From Sarah Bucks, chair of the South Somerset Bridleways Association

Response to Deadline 2,

Responses to questions in table 2:

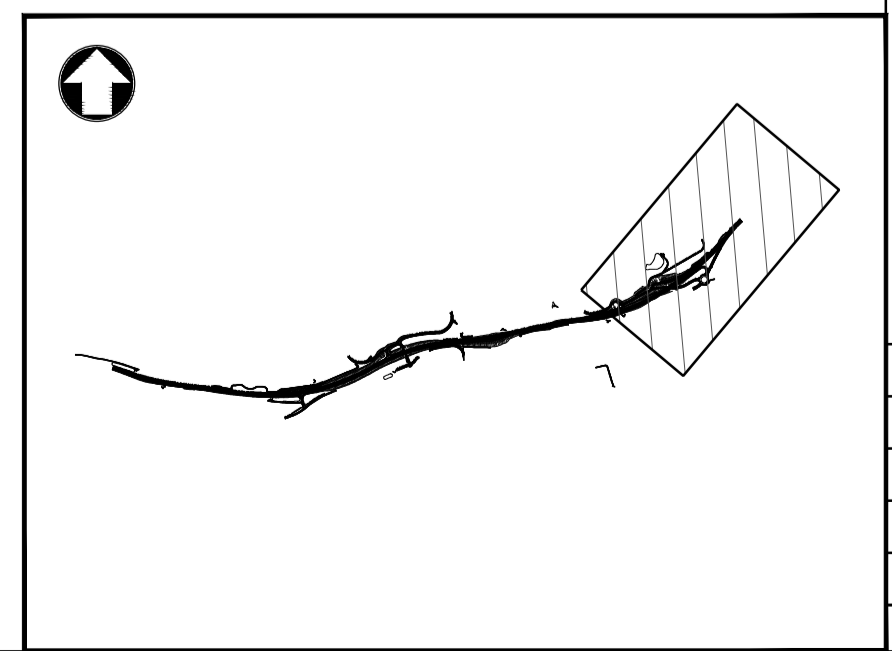
b) Typically equestrians would not be riding or carriage driving at night, thus any lighting would only be advantageous during daylight hours in order to show the tunnel/underbridge in light, and lessen the effects in the darkened underpass of vehicle headlights, many of which are now on all the time a vehicle is in use, causing possible problems to equestrians.

Appendix 1 APPROPRIATE MITIGATION FOR STOPPING UP OF TERMINUS OF BRIDLEWAY Y 30/28 (EASTMEAD LANE)

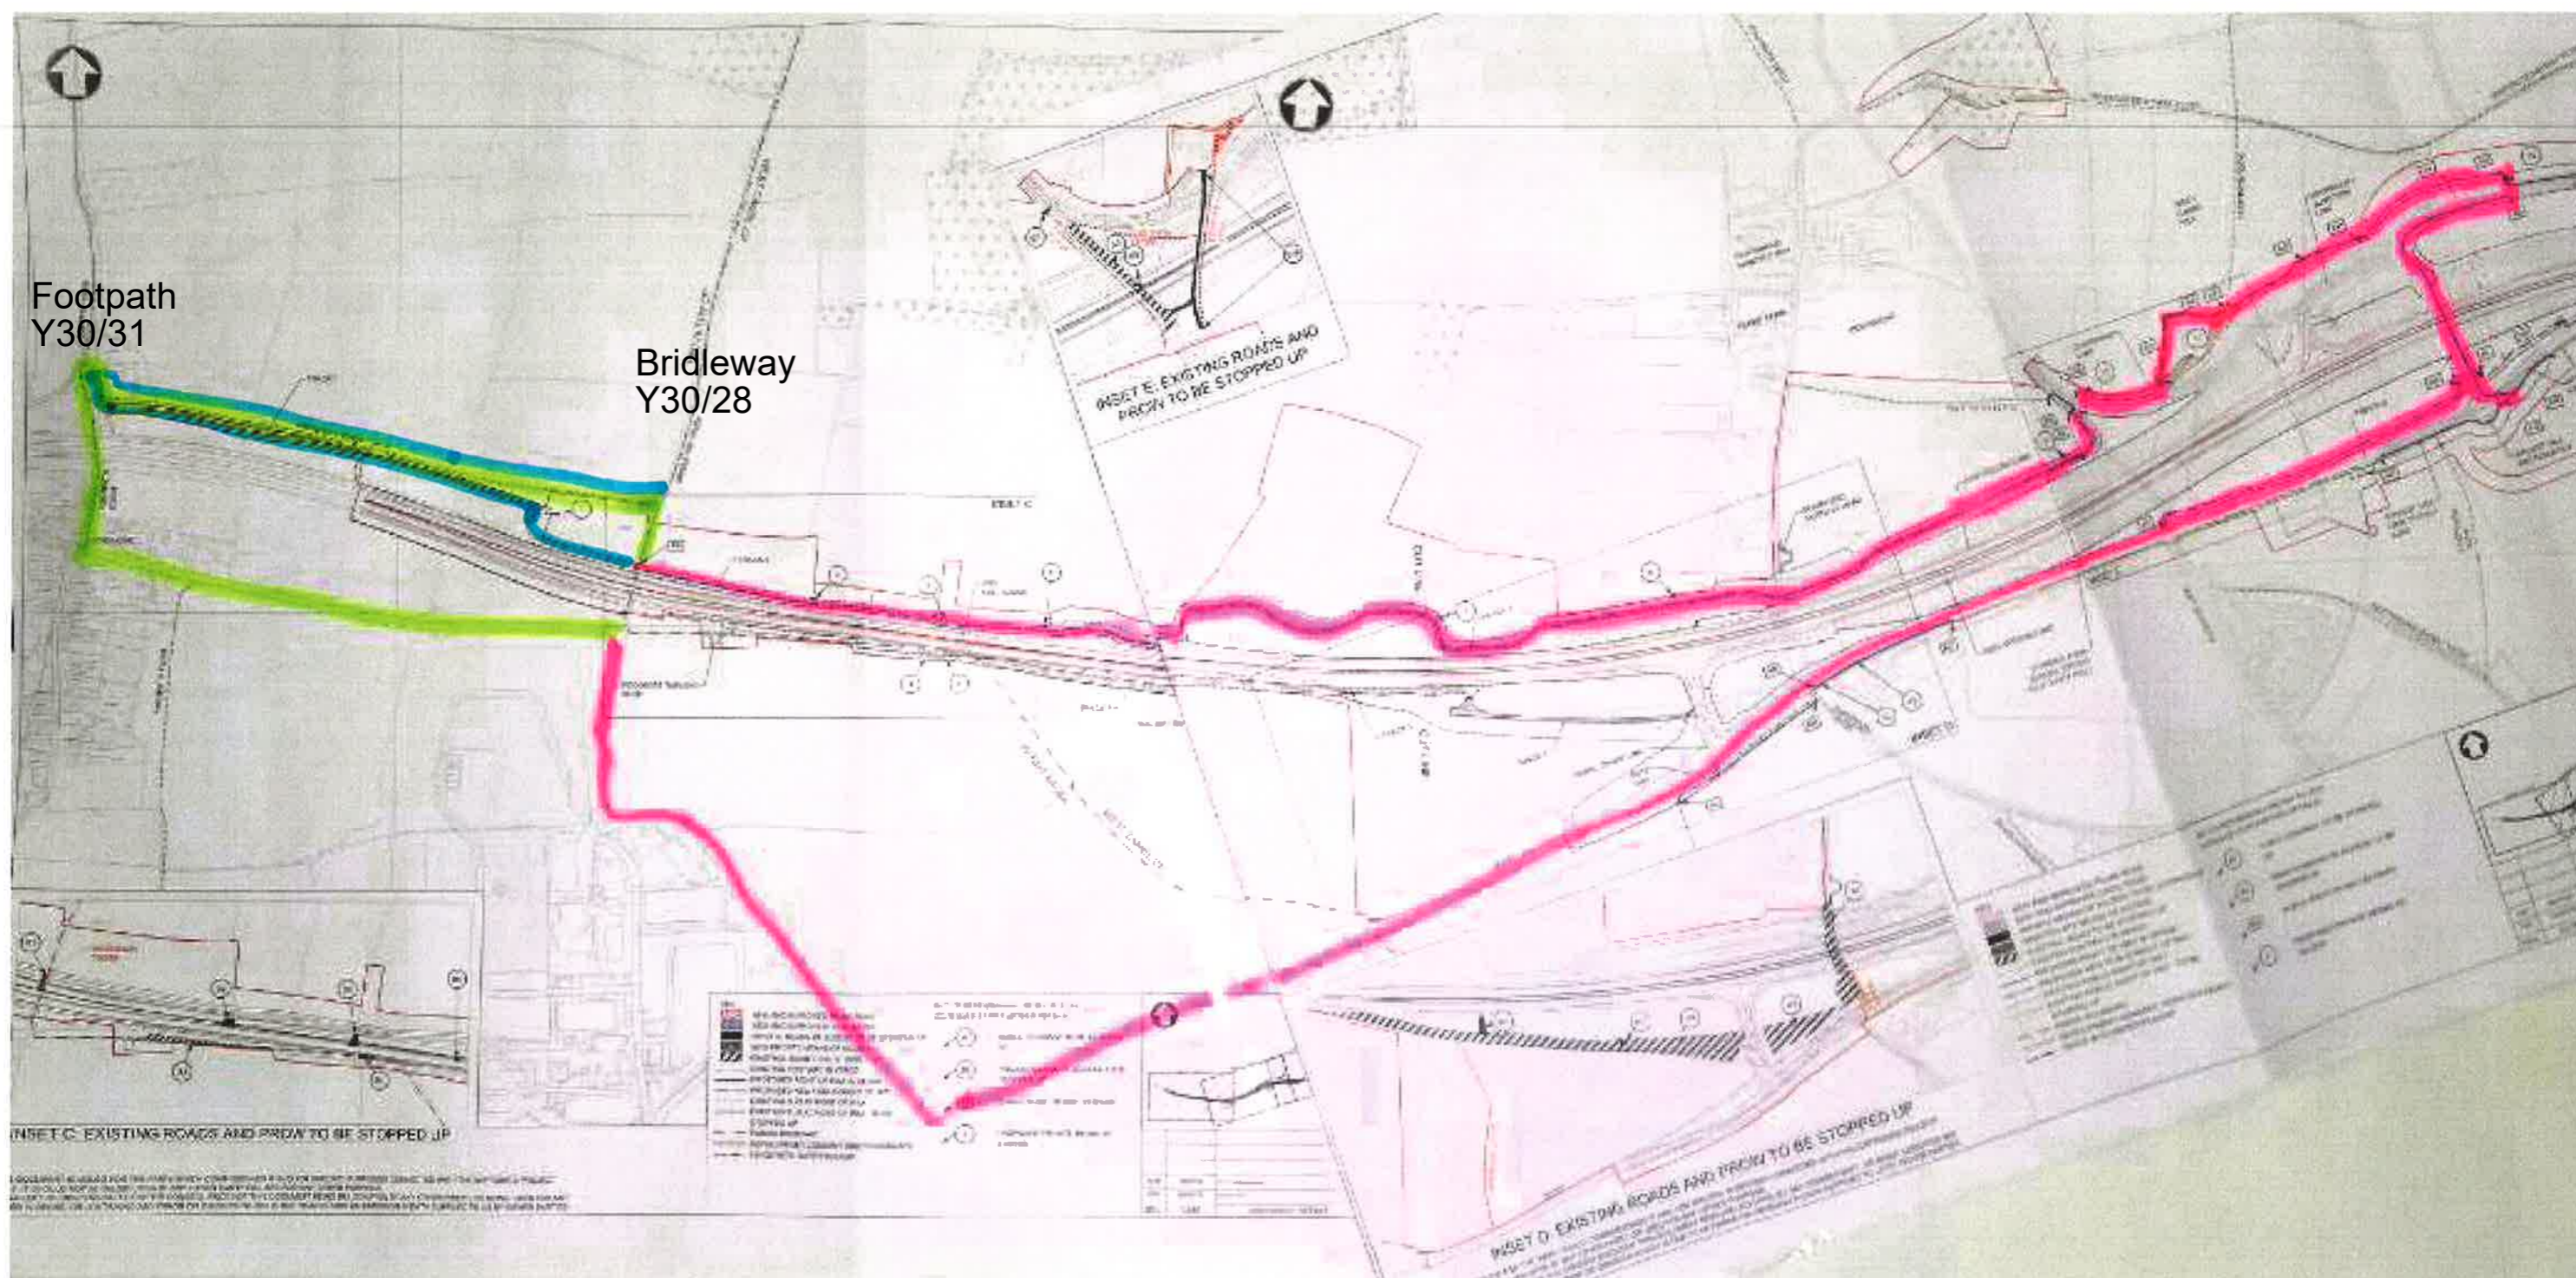
No provision has been made for travelling between Podimore and Eastmead Lane. Dedicating Restricted Byway rights over the bridge at Podimore and then eastwards to Eastmead Lane would provide route of realistic length to join Podimore to the southern end of Eastmead Lane and the network of NMU routes north of the A303. The alternative route from Podimore to Cary Fitzpaine is along the A37, which we consider to be dangerous for equestrians, and motorists do not expect to encounter horse being ridden or driven on major roads such as the A37.

1.10.12 Would the suggested tunnel/over bridge at the end of Gason Lane or nearby be considered here? Likewise, a grade separated crossing at the southern end of Eastmand Lane.
